**RE: Telopea Concept Plan and Stage 1A Residential, Retail, Child Care and Aged Care –  
Adderton Road, Telopea – SSD-14378717  
Transport and Accessibility Impact Assessment Addendum**

The objective of this TAIA Addendum is to provide responses to the traffic and transport related RFIs received from City of Parramatta Council (Council), NSW Department of Planning, Industry and Environment (DPIE), and Transport for NSW (TfNSW).

TELOPEA URBAN RENEWAL PROJECT MASTERPLAN TURNING PATHS SHEET 1				PROJECT No: 110500-04
				SHEET No: DA017
AZIMUTH: M.G.A.	DATUM: A.H.D.	ORIGIN: SSM 1112	PLAN No: 110500-04-DA017	2

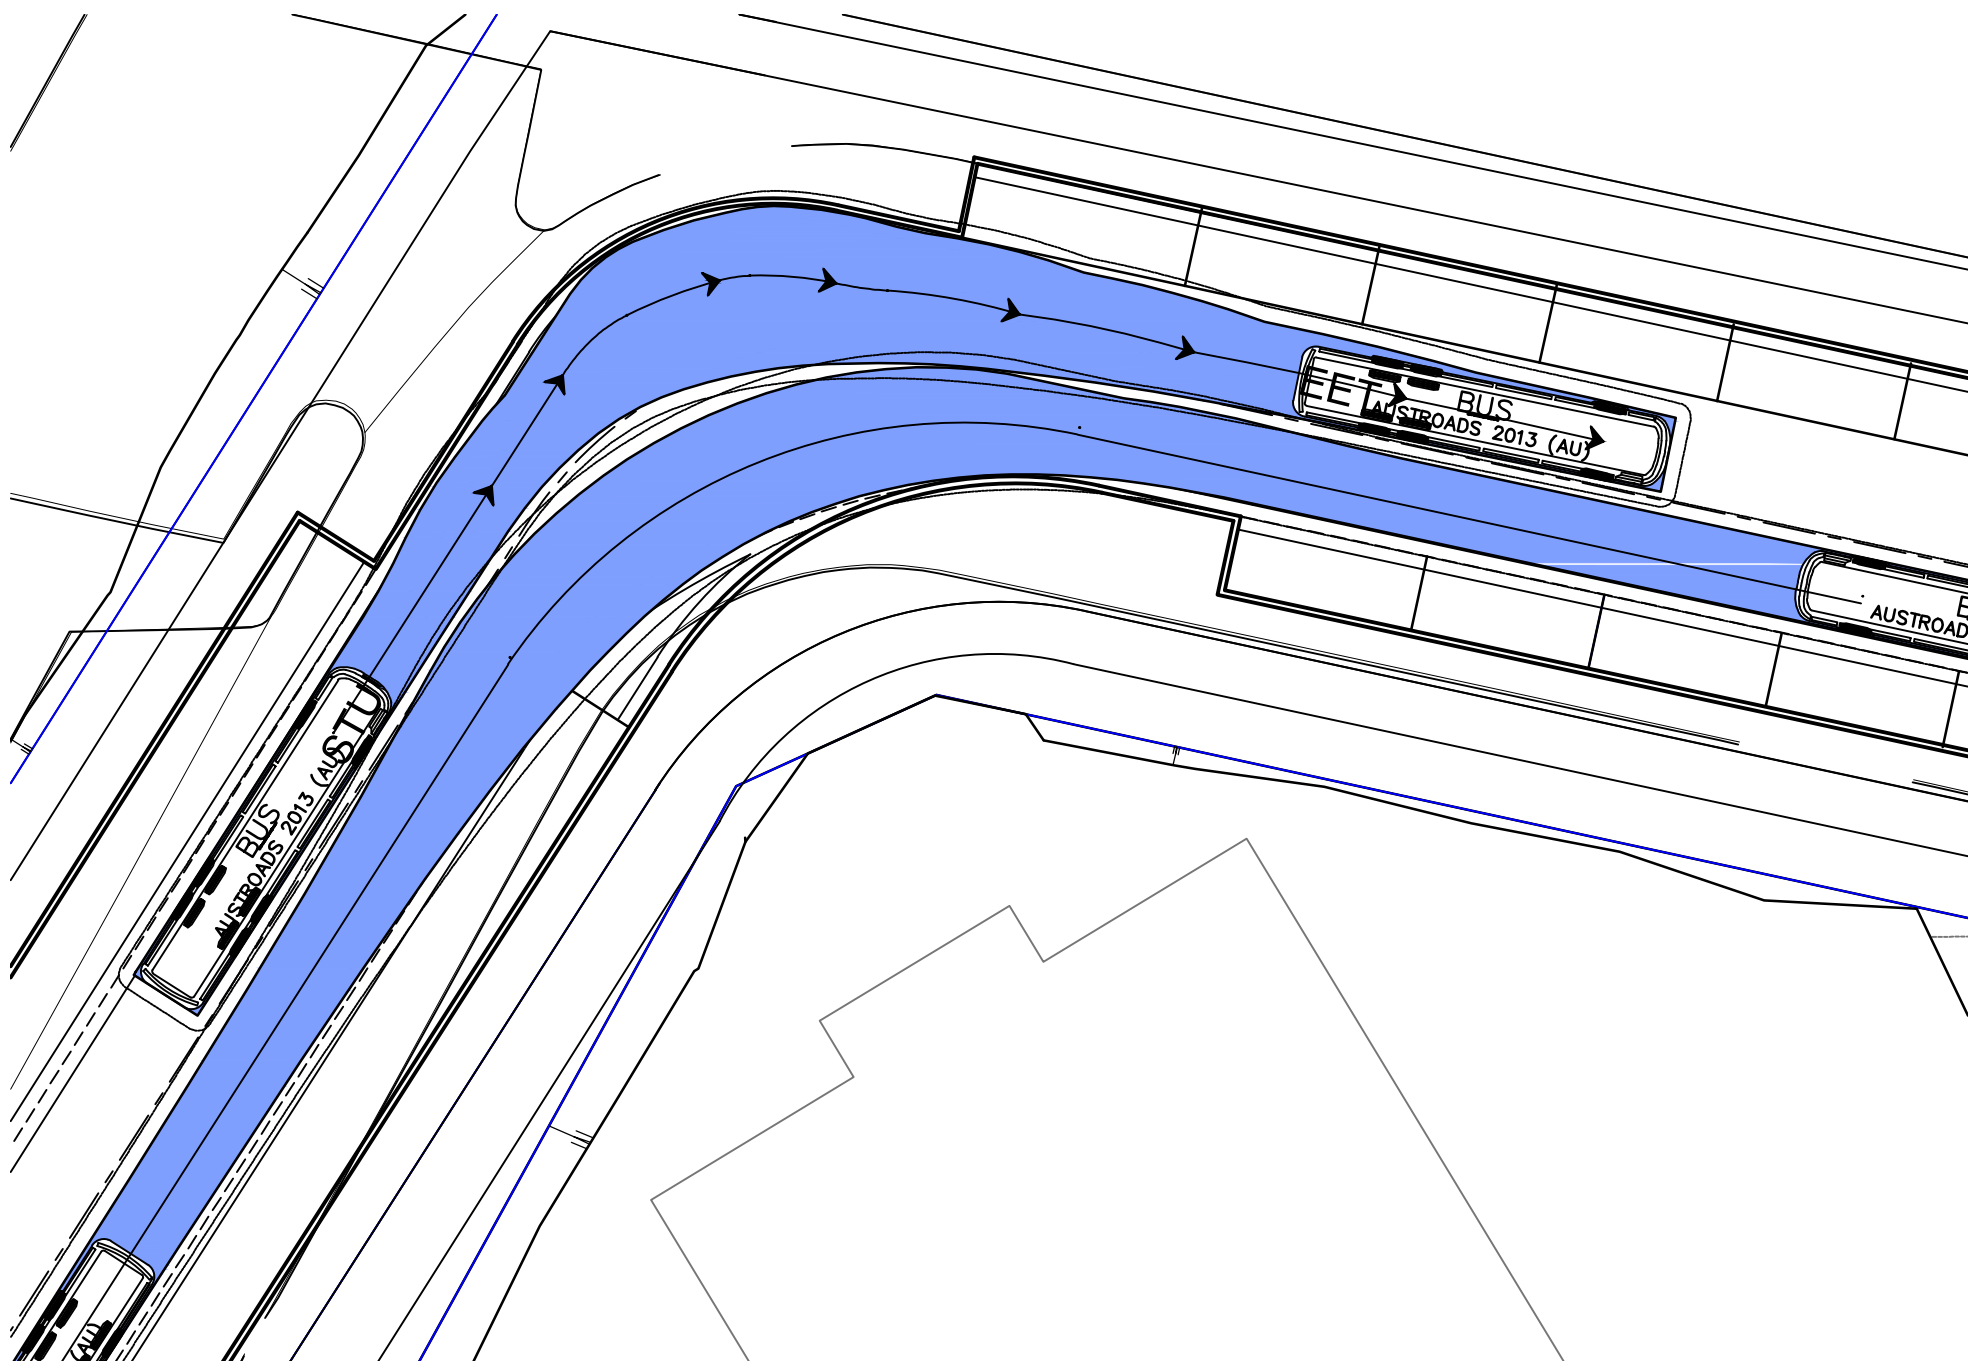
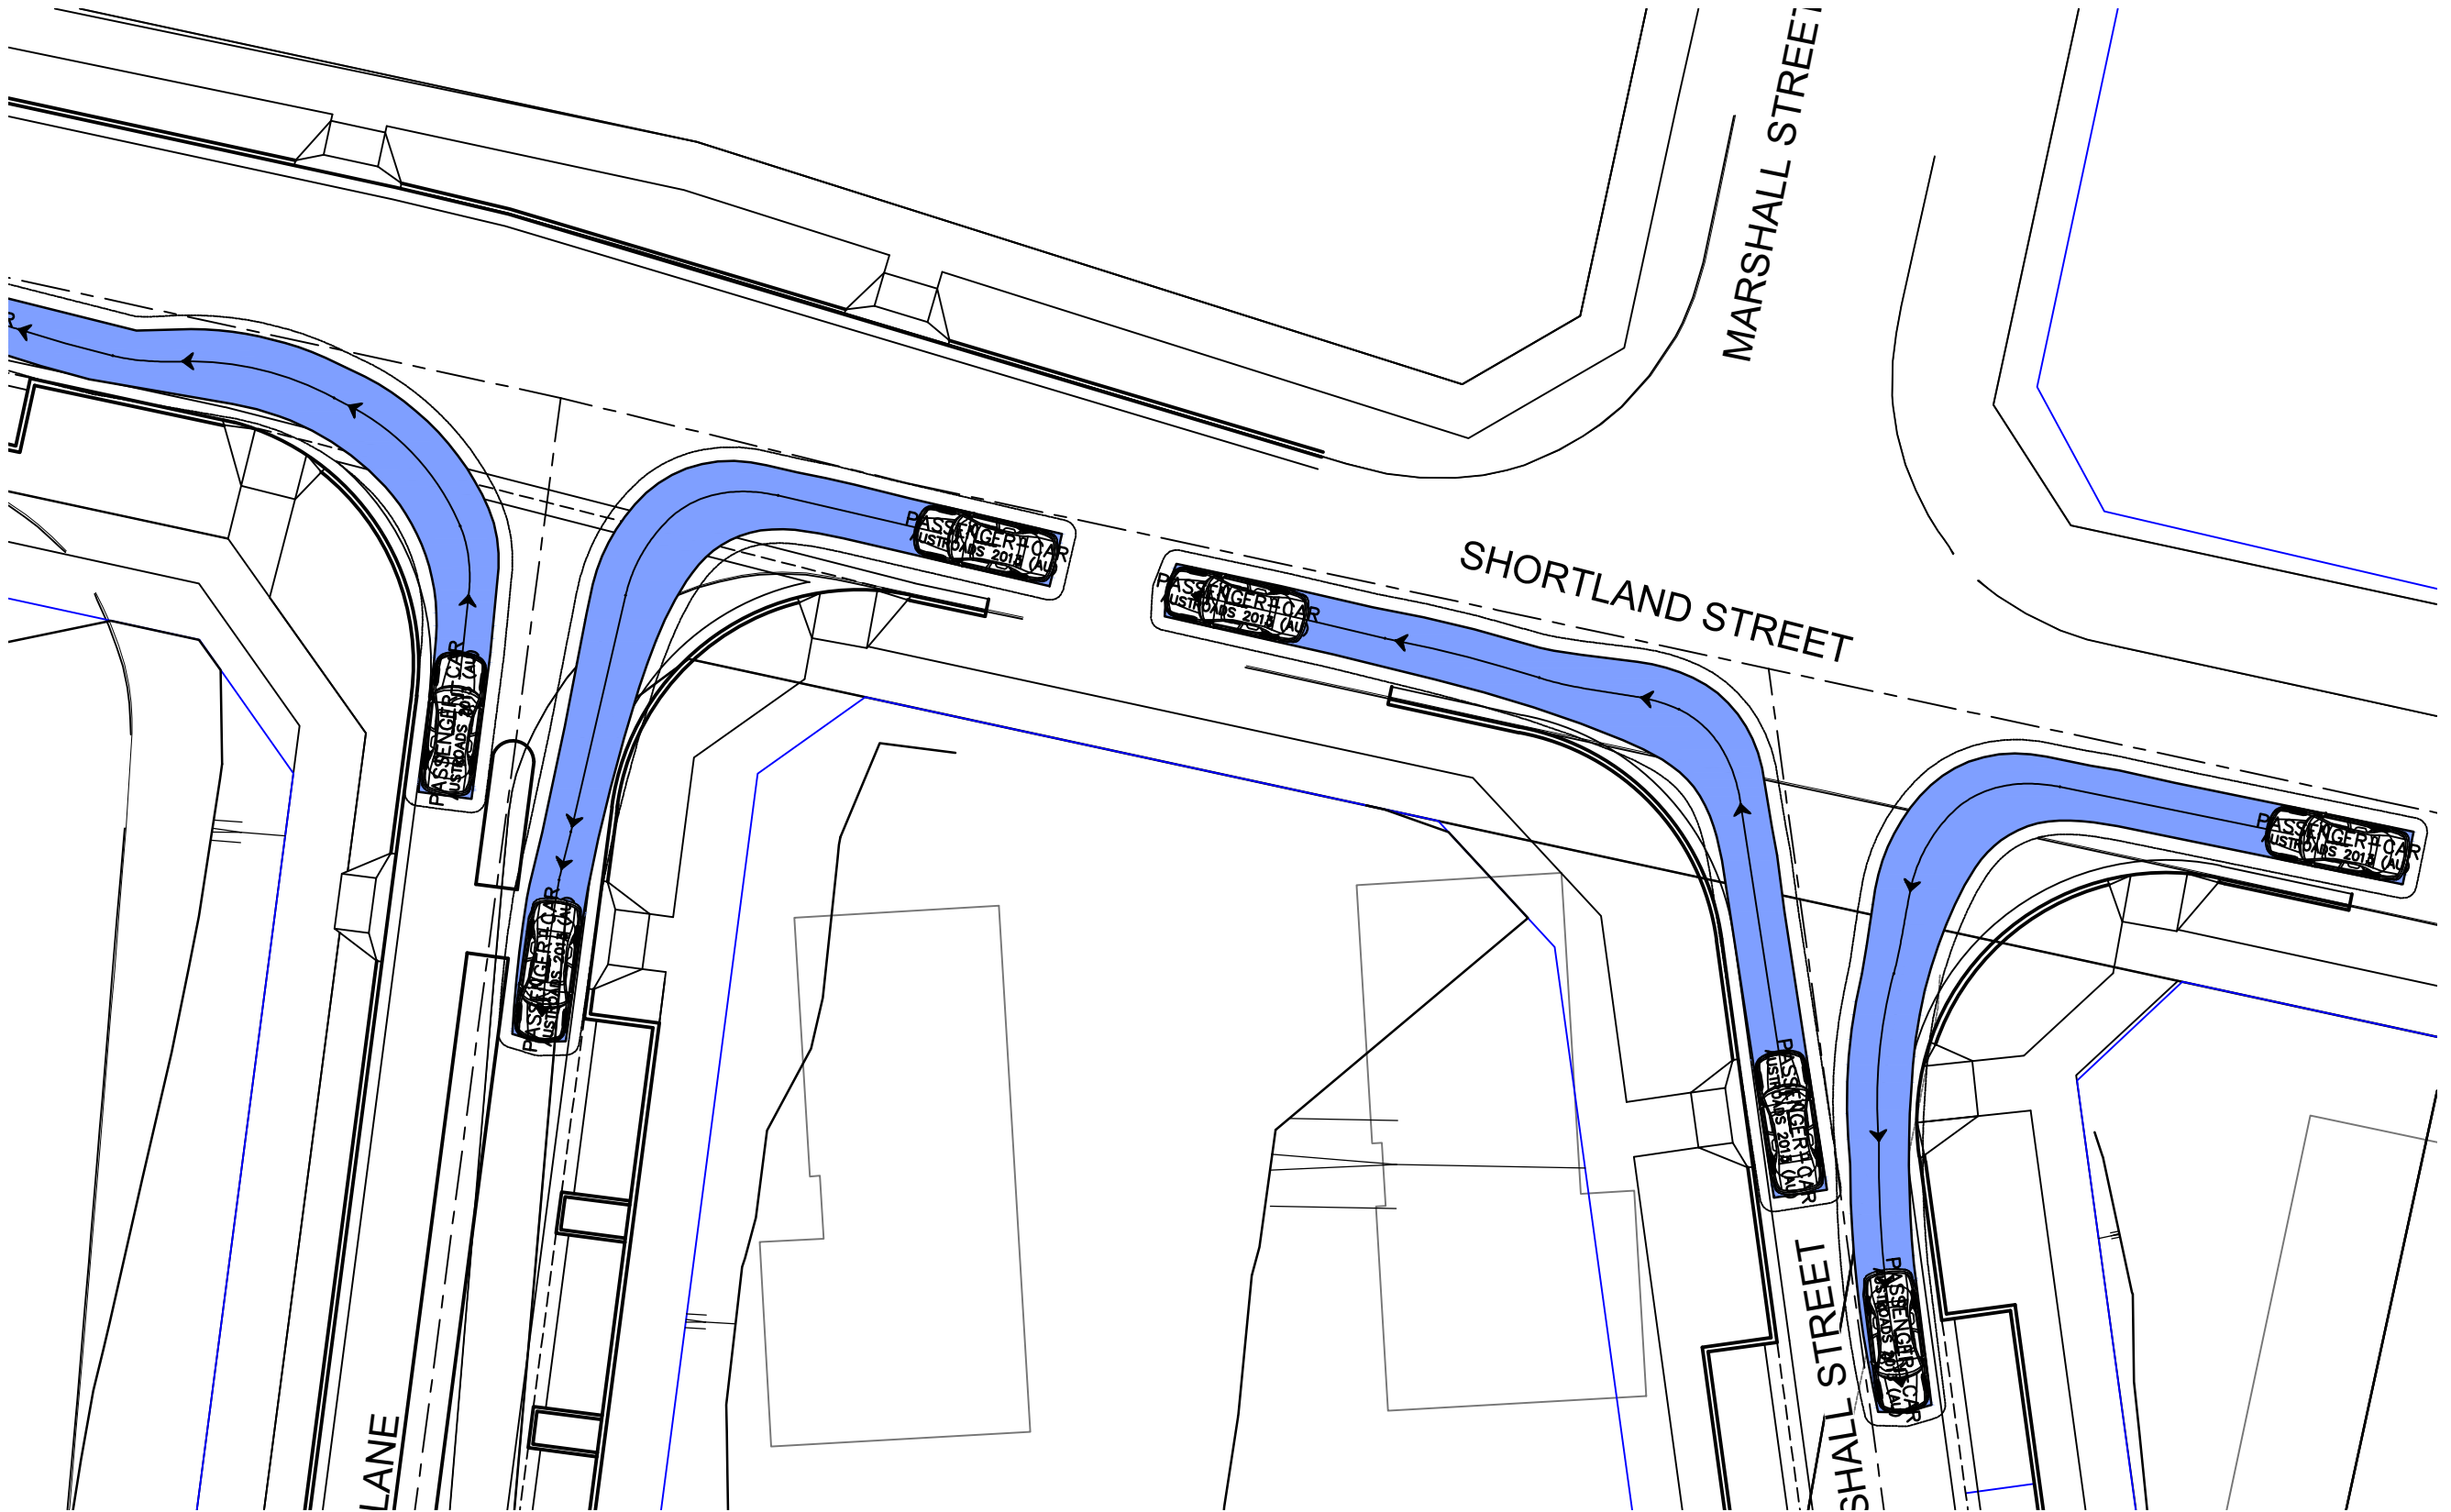
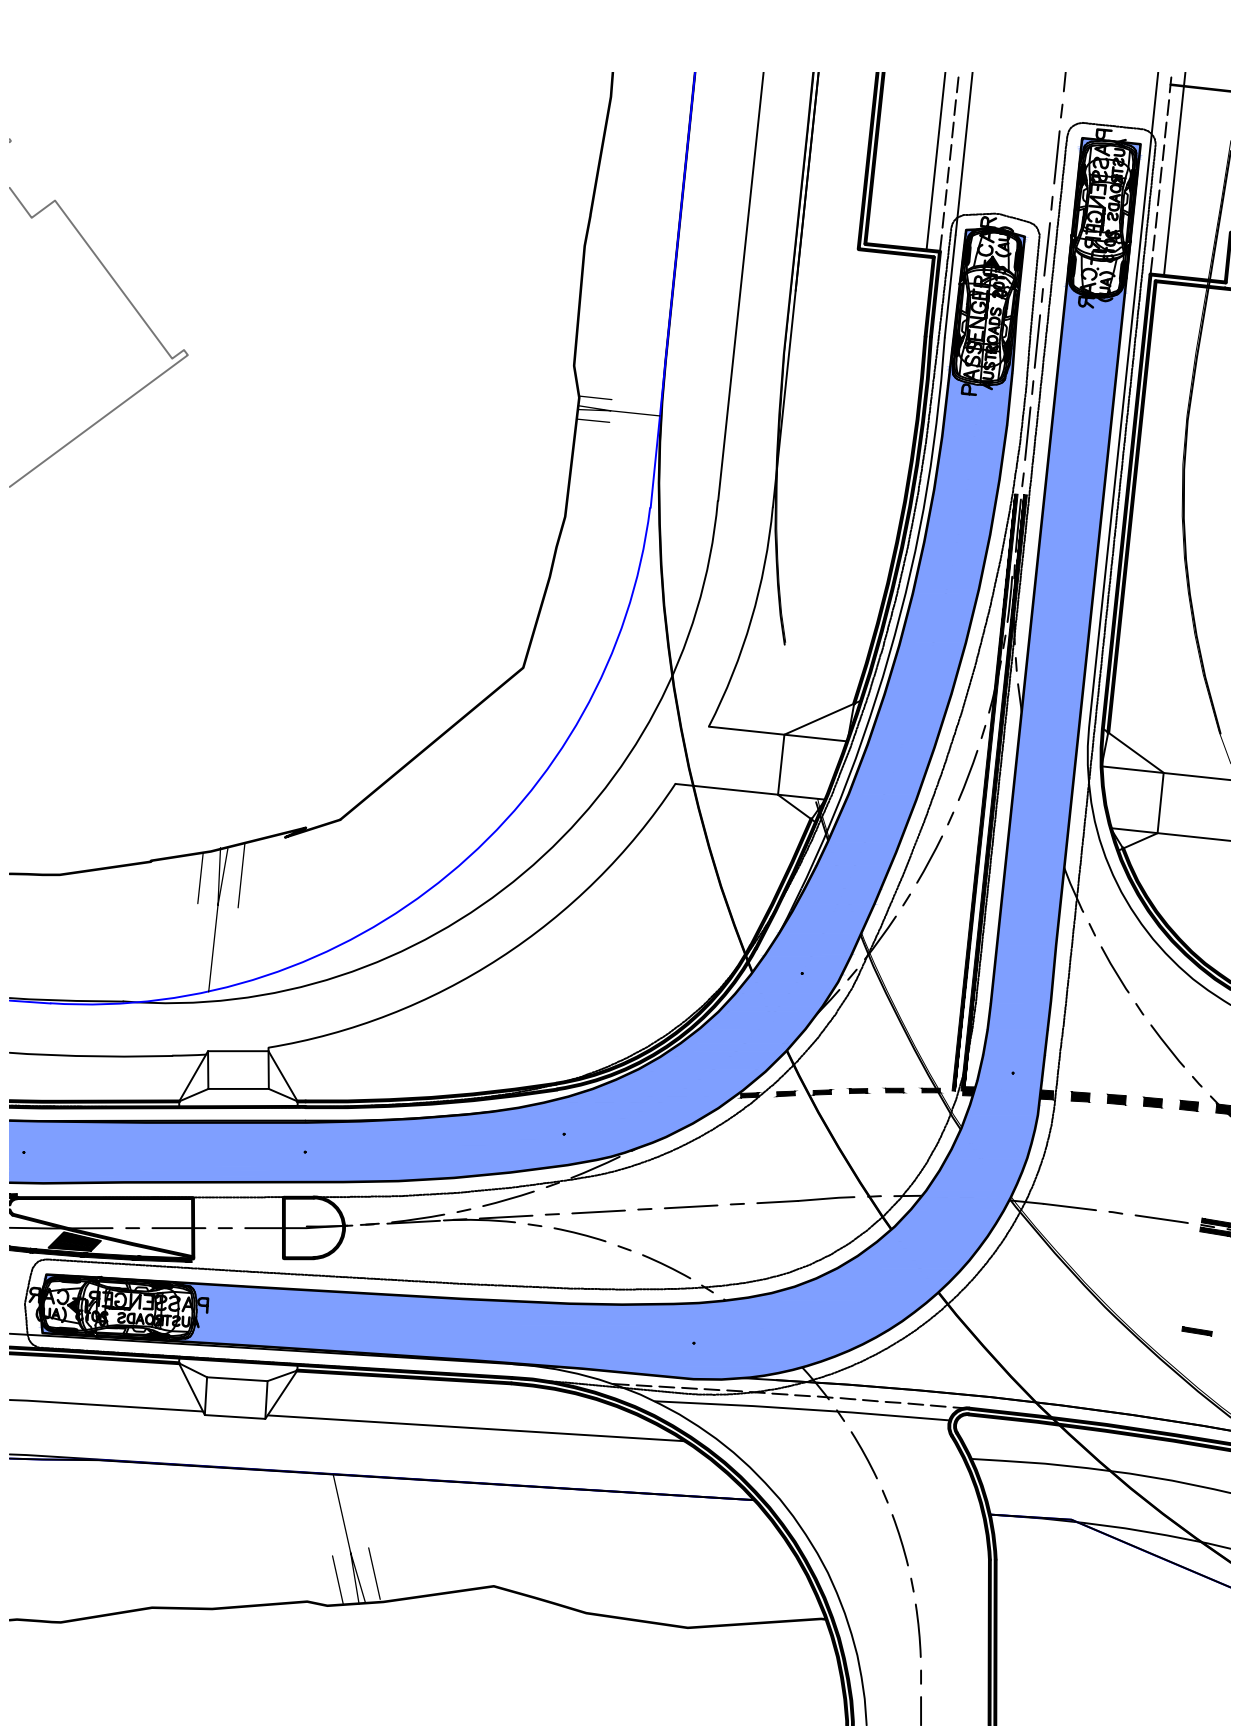
<p><b>14</b></p>	<p><b>Waste Management</b></p>	
<p><b>14.2 Comments (Attachment B) - Waste Truck</b></p>	<p>Trucks are required to enter and exit in a forward direction and the use of a turn table is not permitted. Council requires trucks to be able to enter and exit in a forward within a threepoint turn. From the provided plans, it is not clear whether the waste holding area is located sub-street level. Further detail is required to understand the access, as access into areas below street level is generally not supported. Council also requires 4.5M clearance height throughout the truck's entire travel path. All paths travelled by a waste truck will need to be rated to support a 25t vehicle.</p>	<p>The use of a turntable for service vehicle trucks is acceptable as it is permitted under relevant Australian Standards and is used at a number of developments within Greater Sydney, including elsewhere in the City of Parramatta.</p> <p>Conversely, to design for a 12.5m HRV truck to enter in a forward direction, manoeuvre on-site for loading and then exit in a forward direction would result in a significant impact on the development and would represent a poor design outcome for a vehicle that only occasionally requires access to the Site.</p>
